Application number: 2022/93510	
What is the application for?:	Erection of detached dwelling with intergral garage
Address of the site or building:	Shiraz, 142, Upperthong Lane, Upperthong, Holmfirth, HD9 3UZ
Postcode:	HD9 3UZ

User comments

EXISTING & PROPOSED SITE
SECTIONS & KEY PLAN

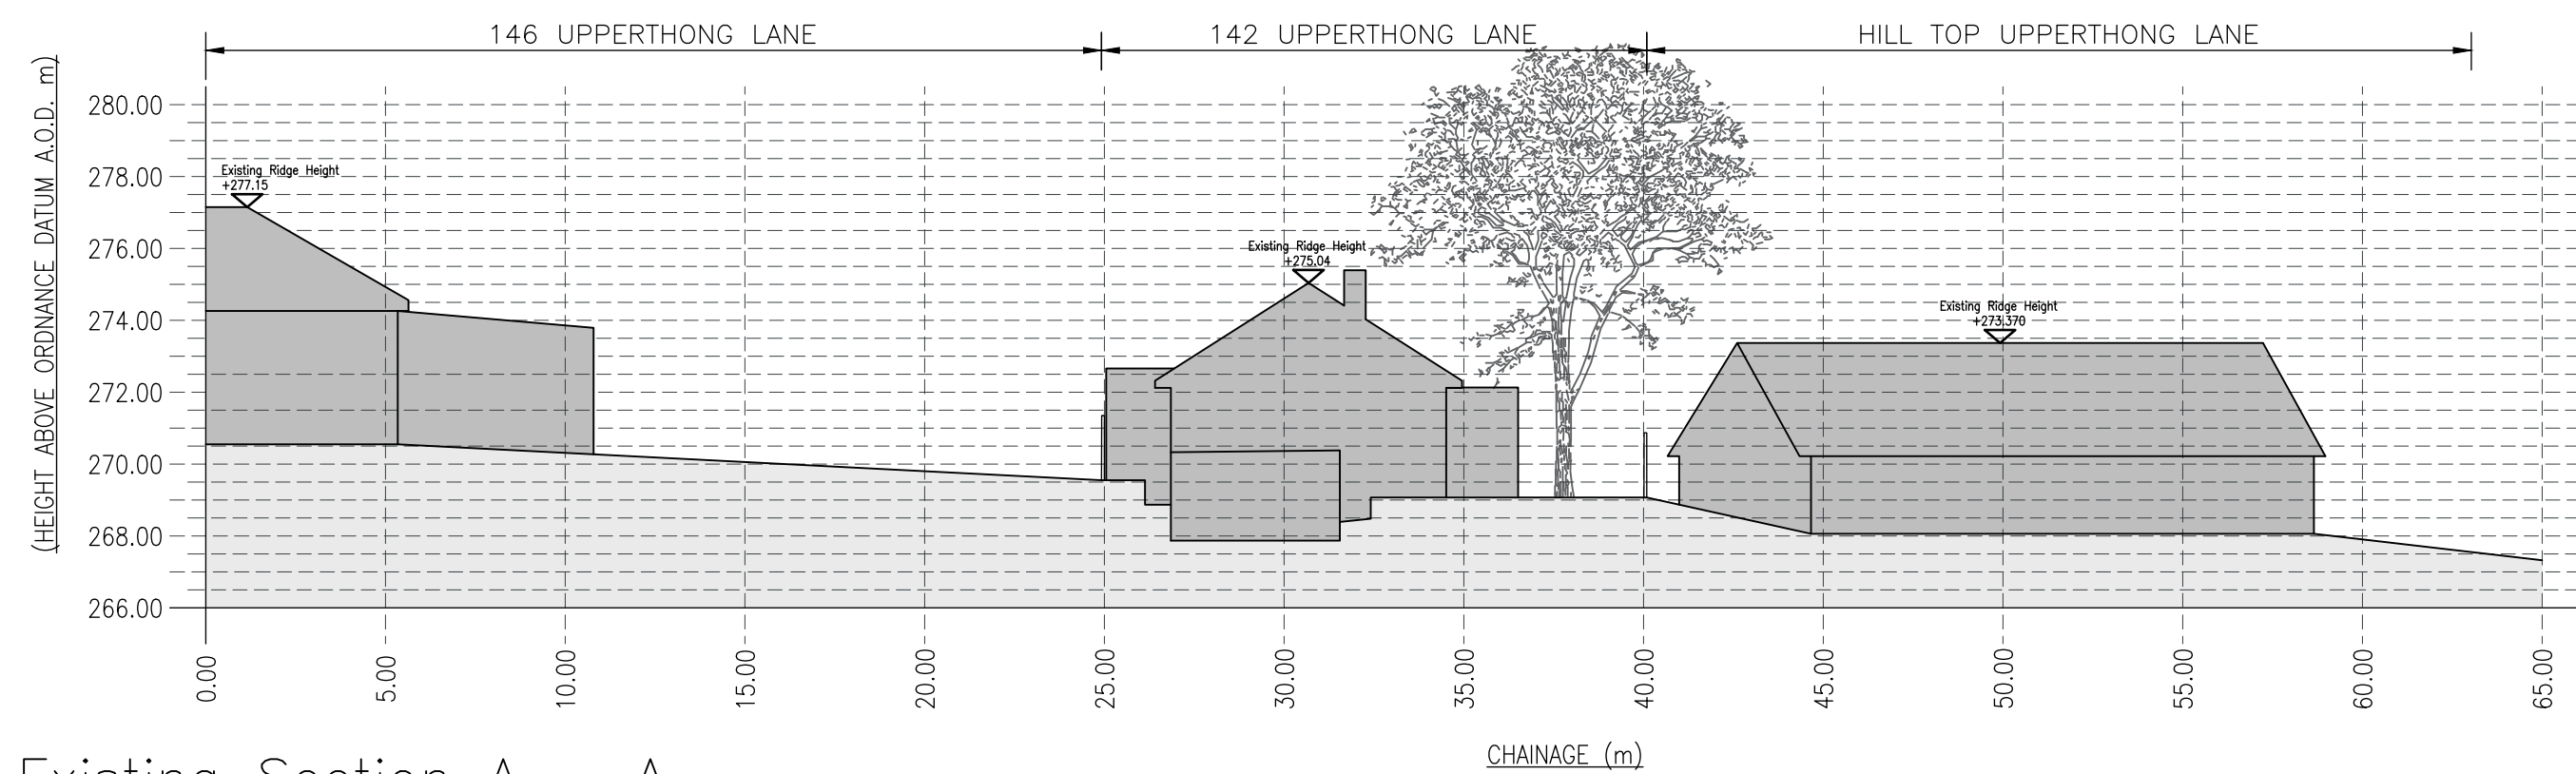
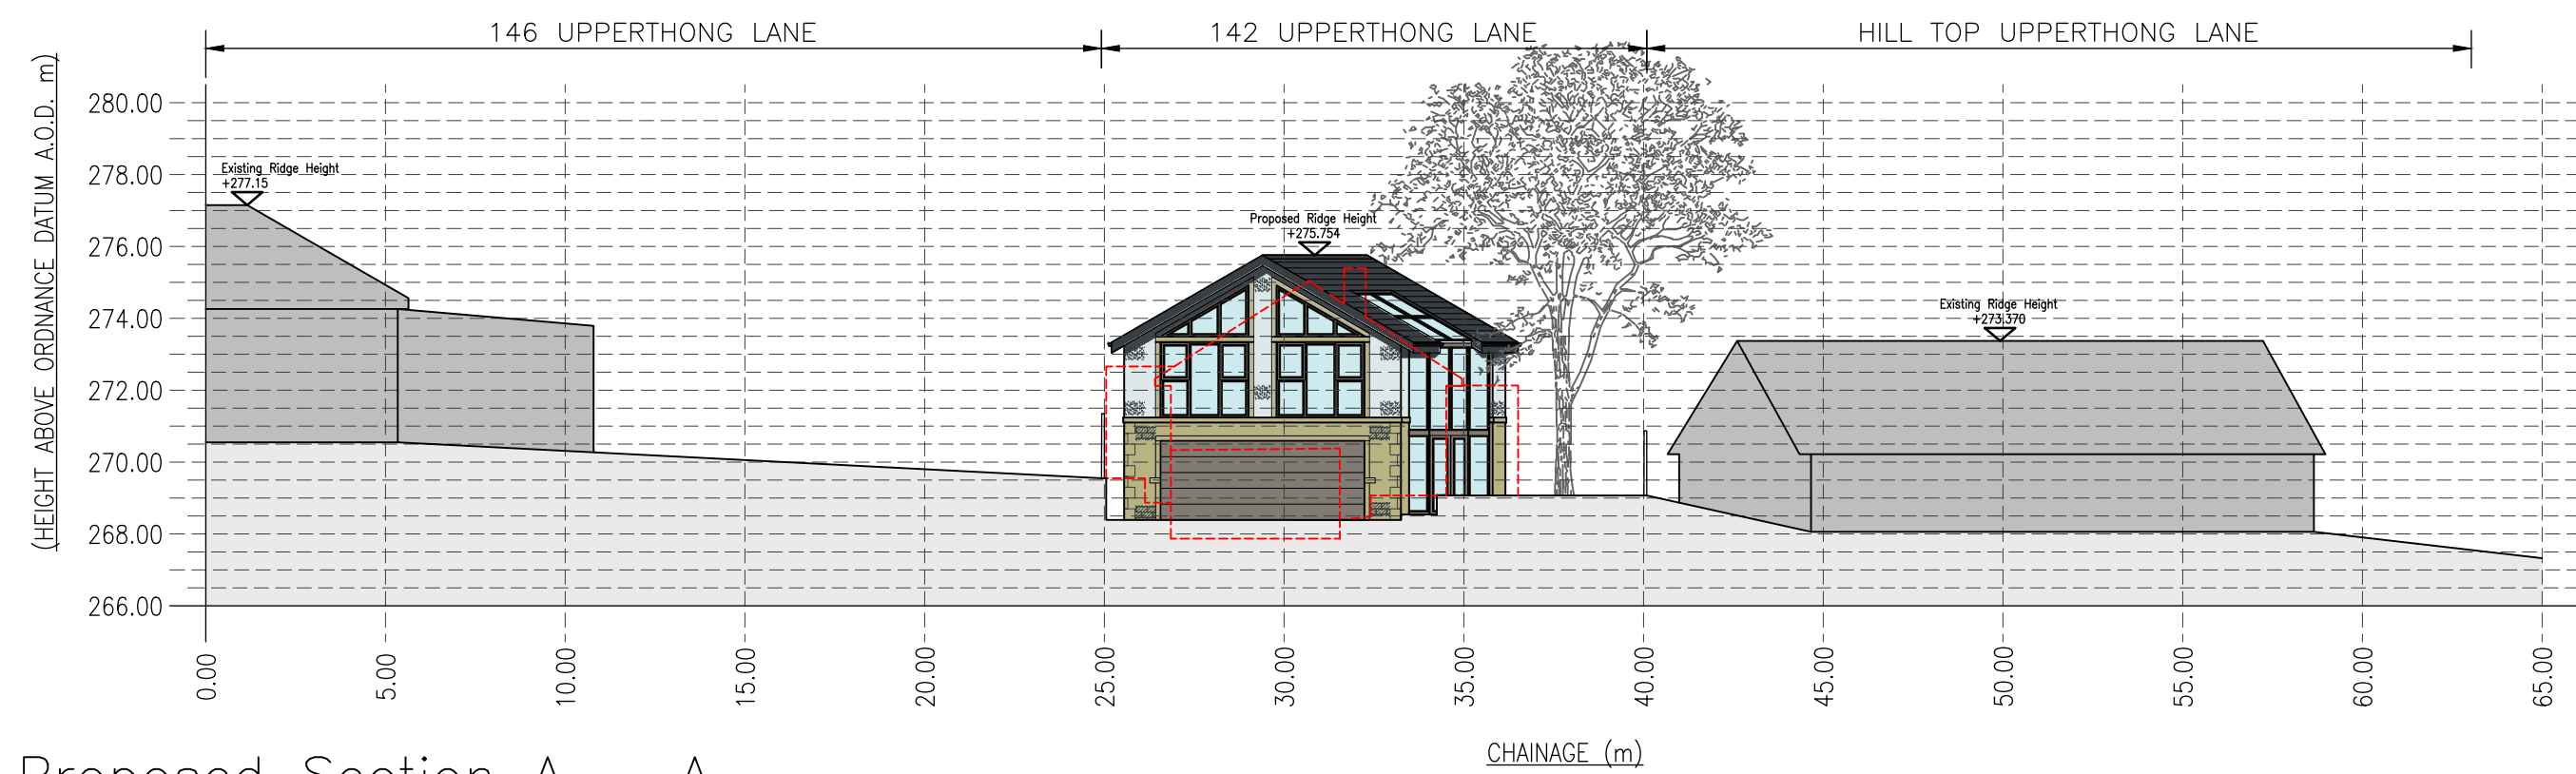
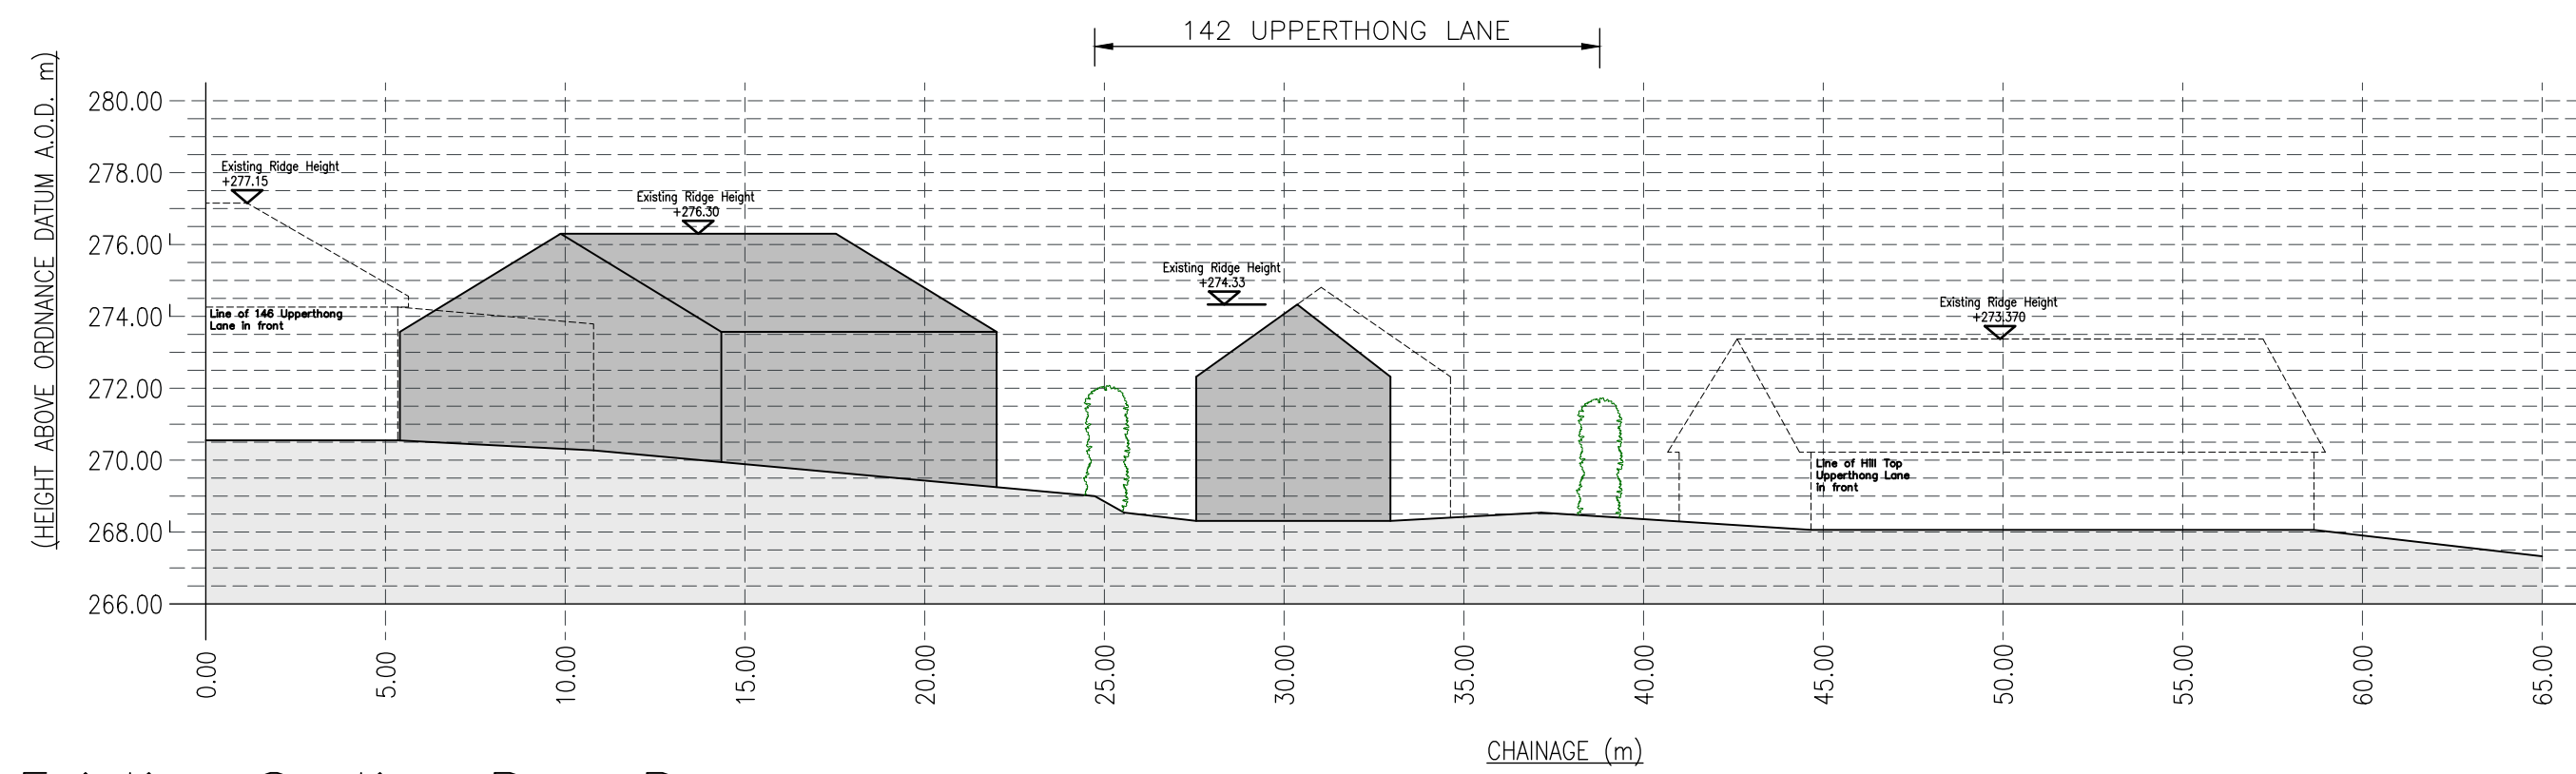
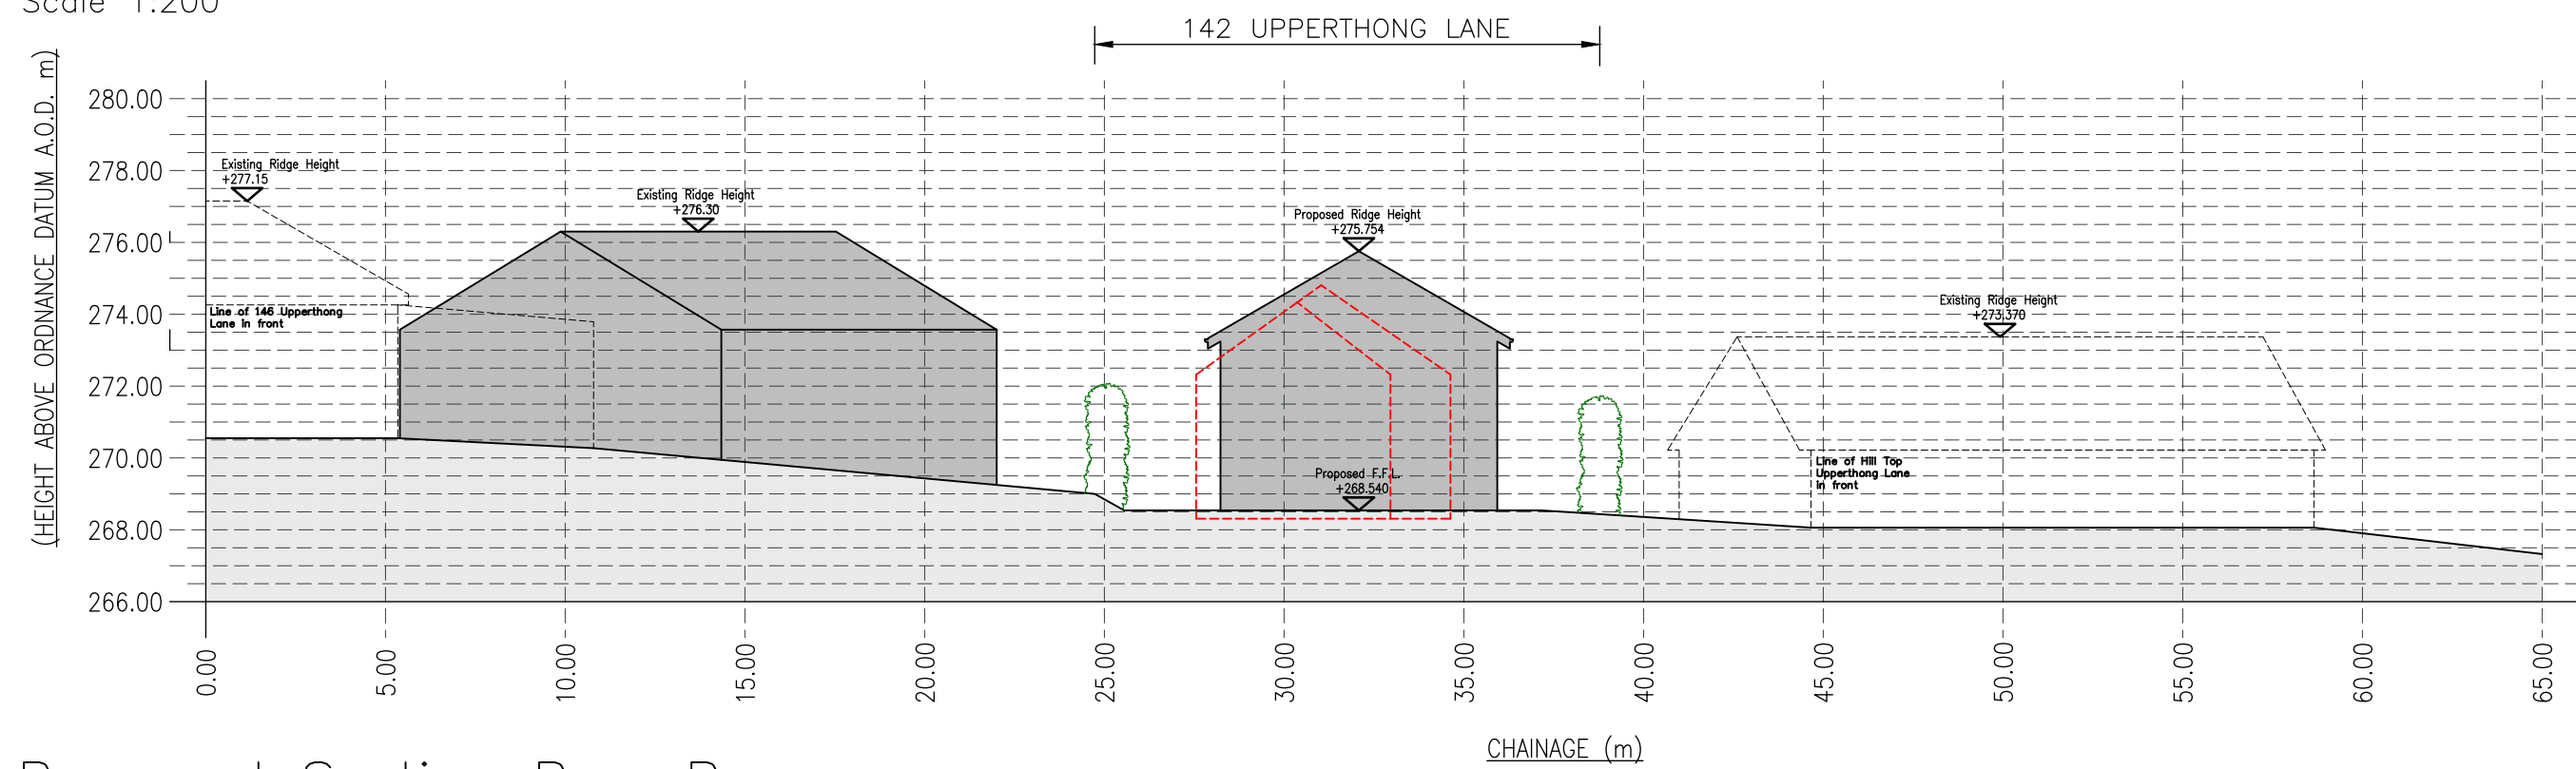
4. The bedroom window of the neighbour at Hill Top to the South East, is currently closest to a single-story porch on Shiraz. The height of the porch and the bedroom window are very similar. The proposed building will be closer to the boundary between the 2 properties for much of its length, and will be 2 stories high. There are also a number of windows on that side of the property, some full length, and along with the atrium, they will affect the neighbour at Hill Top. The ridge will also be higher. Because of this, the neighbour's privacy and outlook, both inside his house and in his rear garden, would be adversely affected.
